# **AQUIND INTERCONNECTOR**

## **Environmental Statement – Volume 3 – Appendix 20.1 Consultation Responses**

Document Ref : 6.3.20.1

**DATE: 14 NOVEMBER 2019**

© WSP UK Ltd

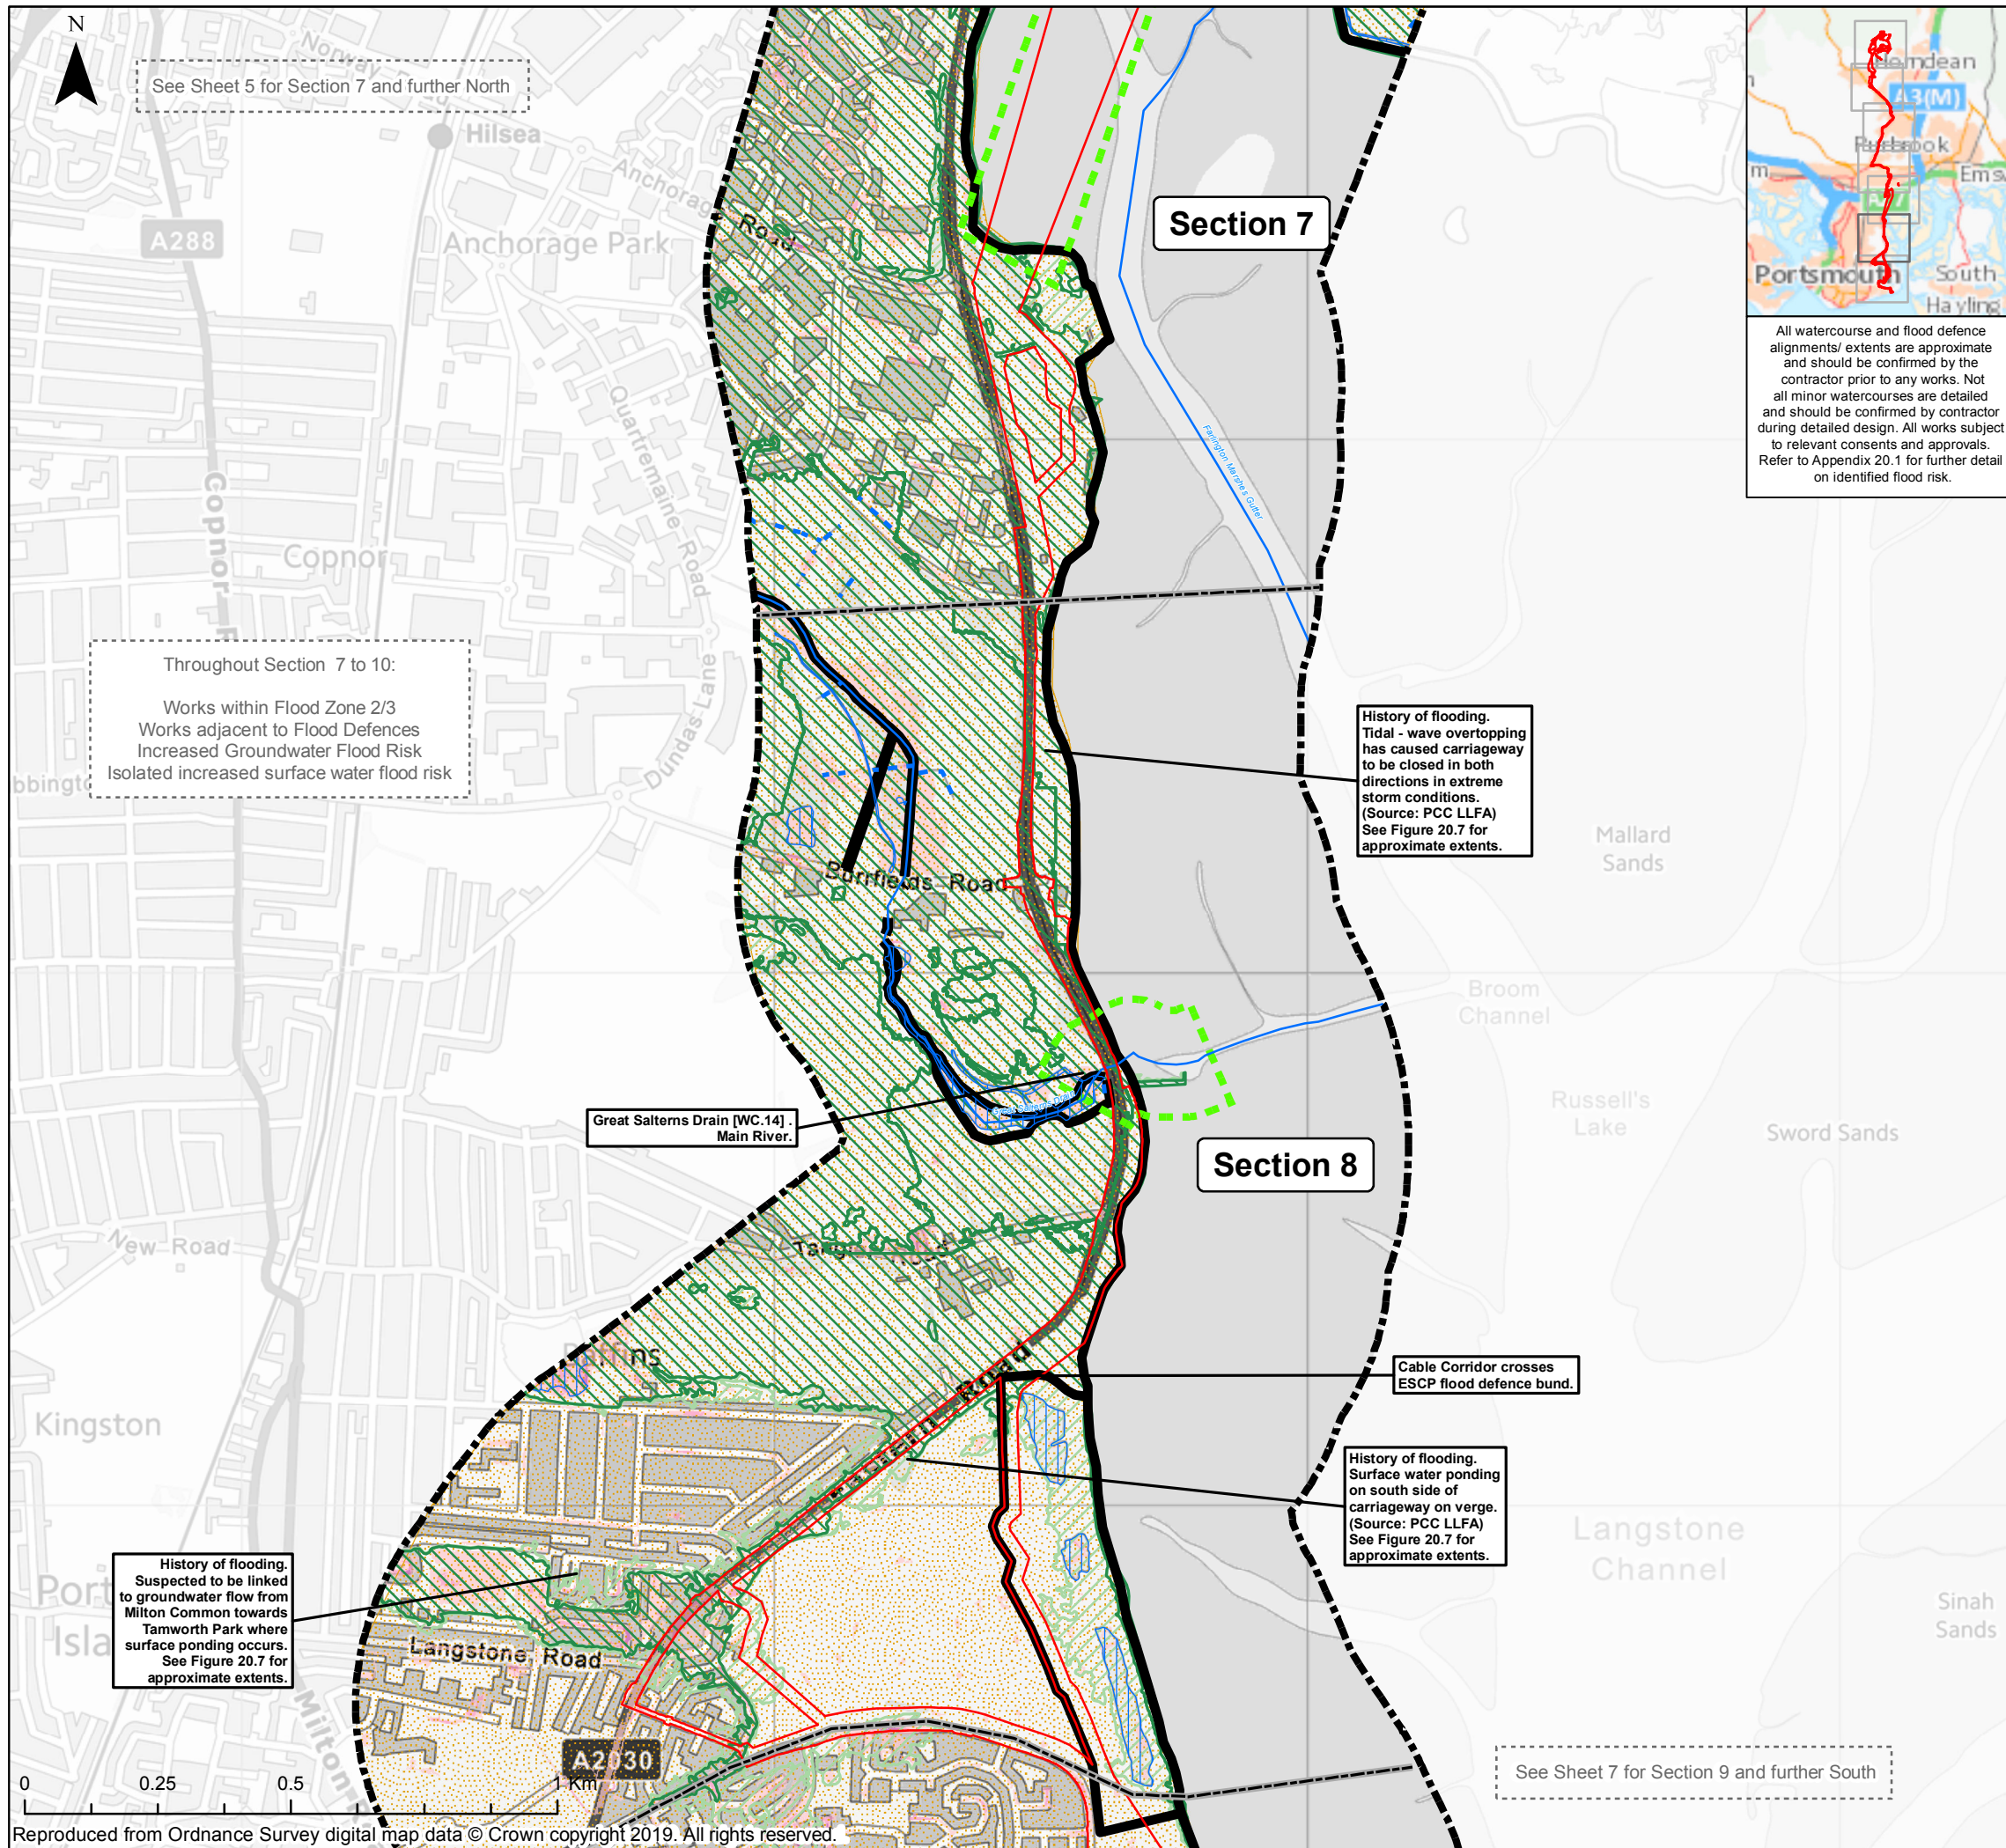
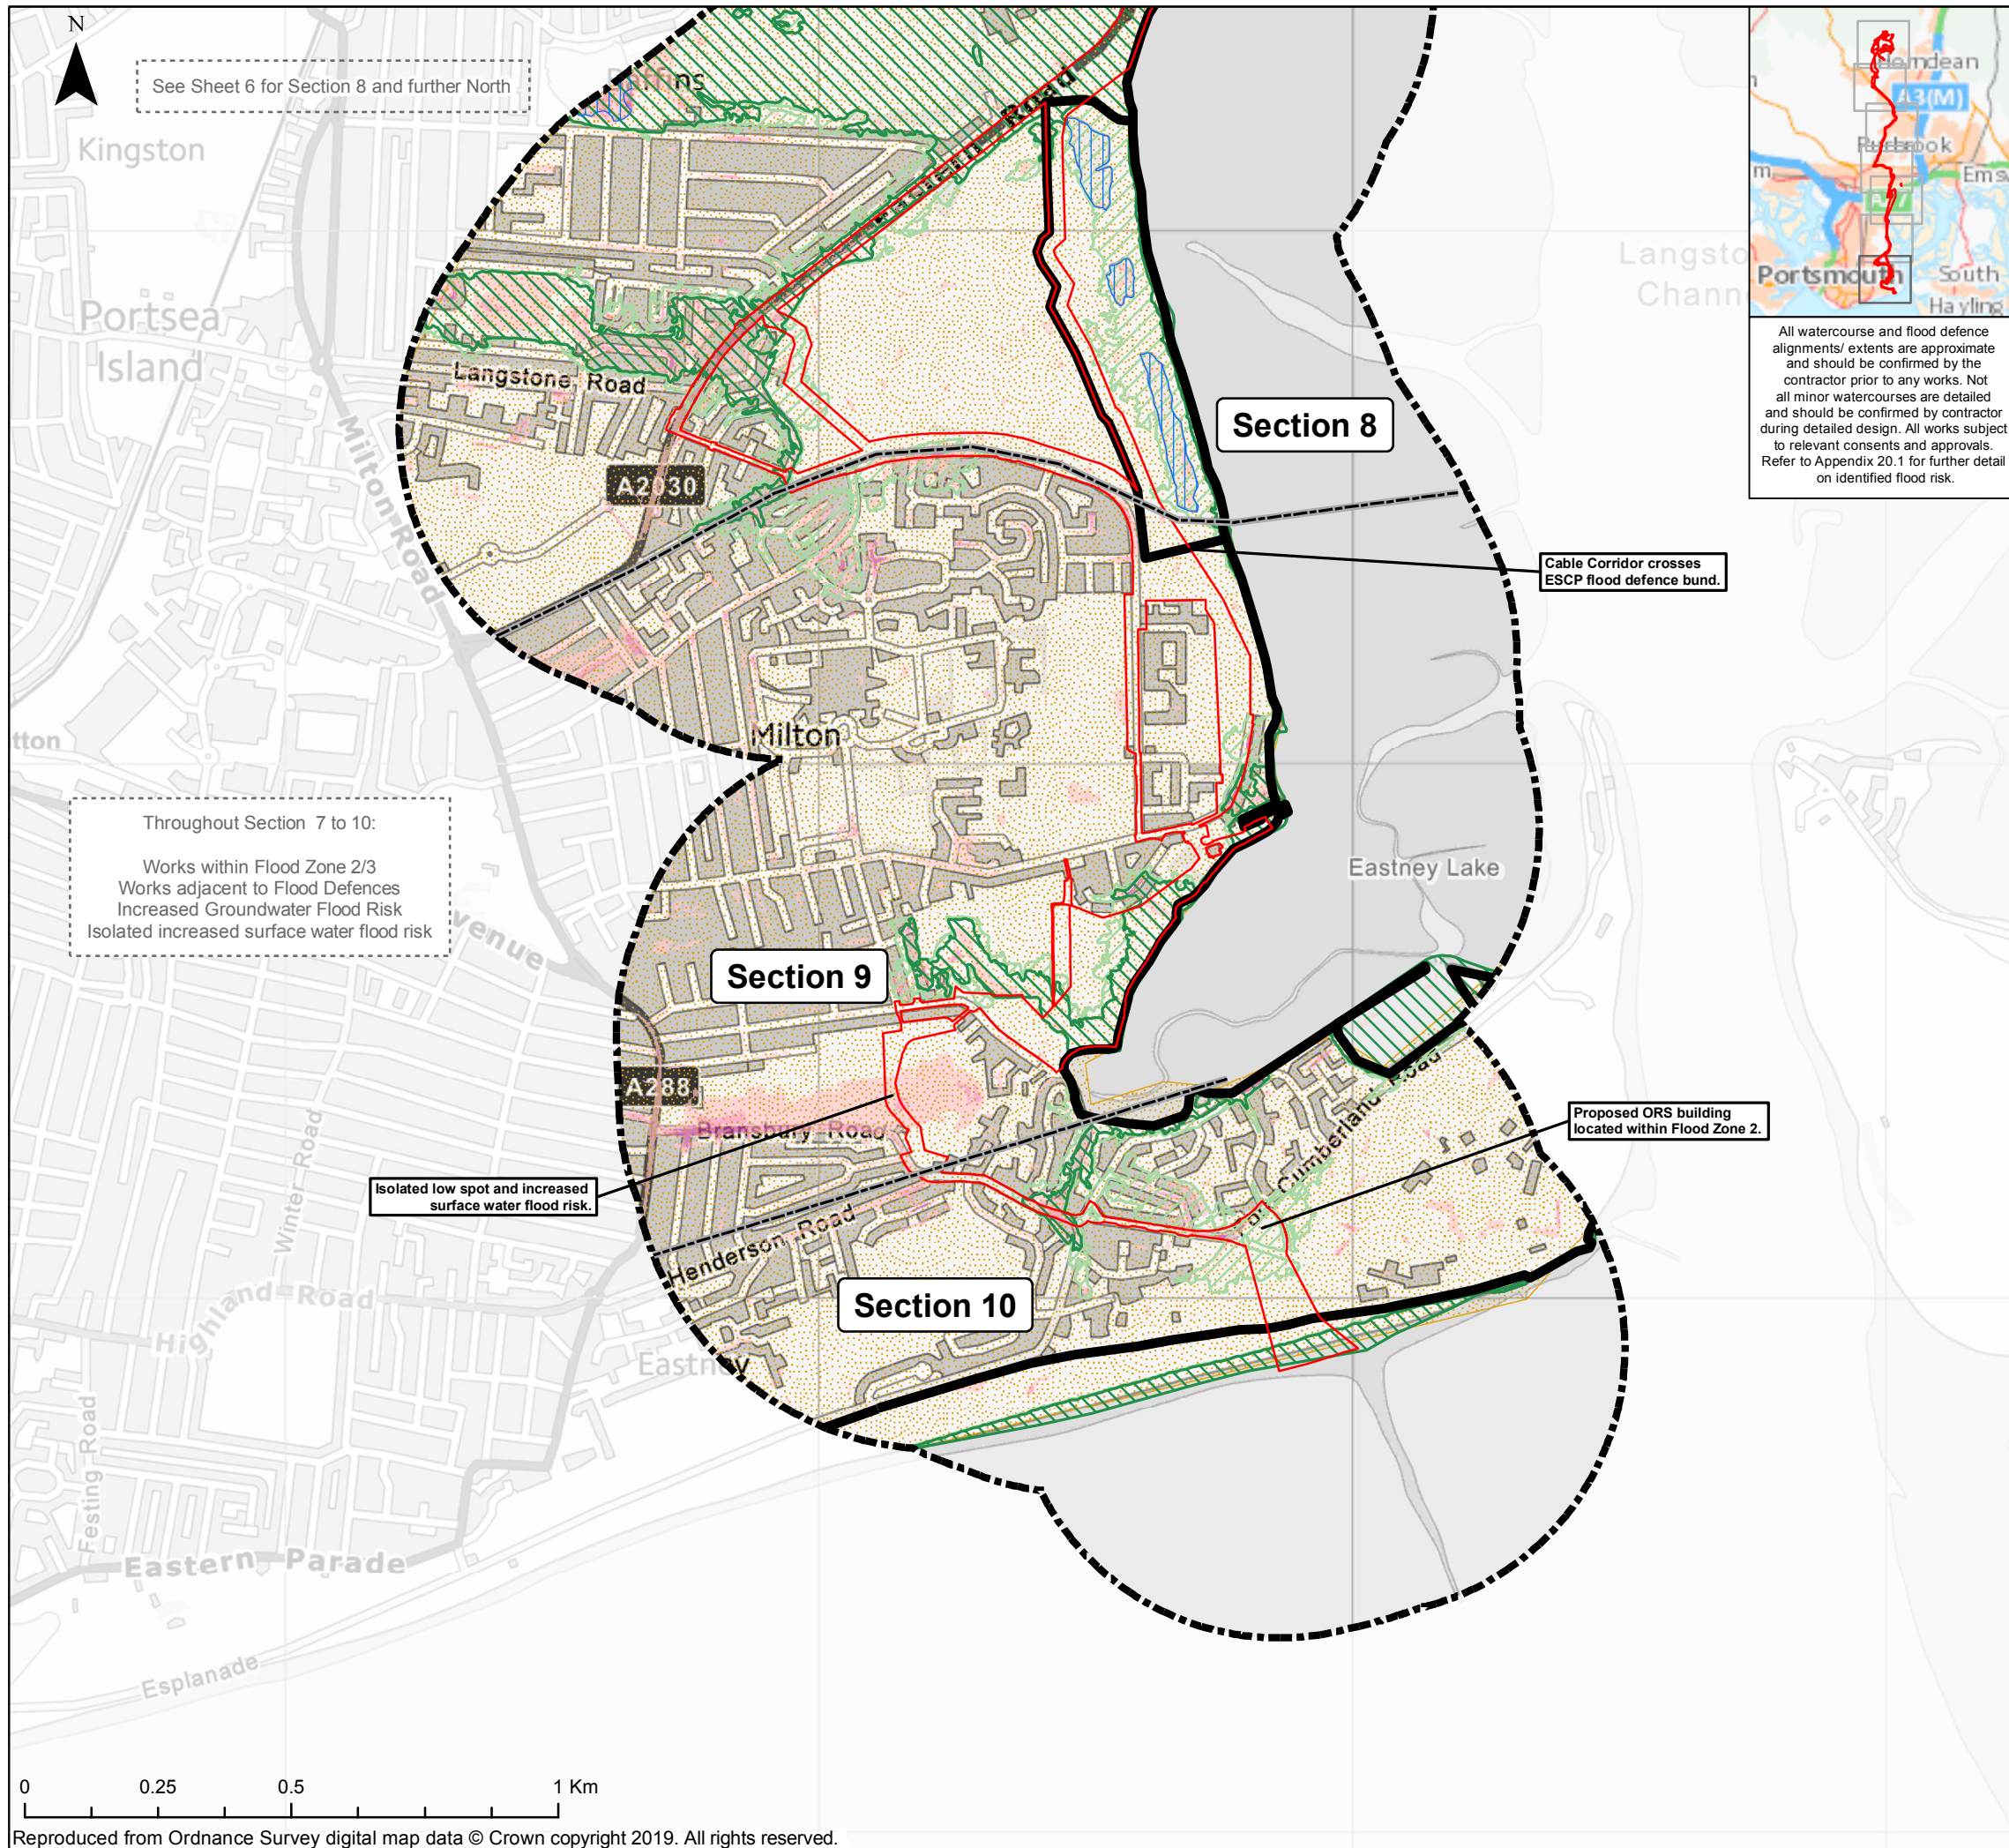
4.17.8	The Scoping Report does not include figures to show the location of potential receptors or the flood maps for the area. The ES must include clear and appropriate figures to support the impact assessment, including those in support of any FRA and WFD Assessment.	Figures 20.1 to 20.8 of the ES Volume 2 (document reference 6.2.20.1 to 6.2.20.8) support the assessment, FRA and WFD assessment.
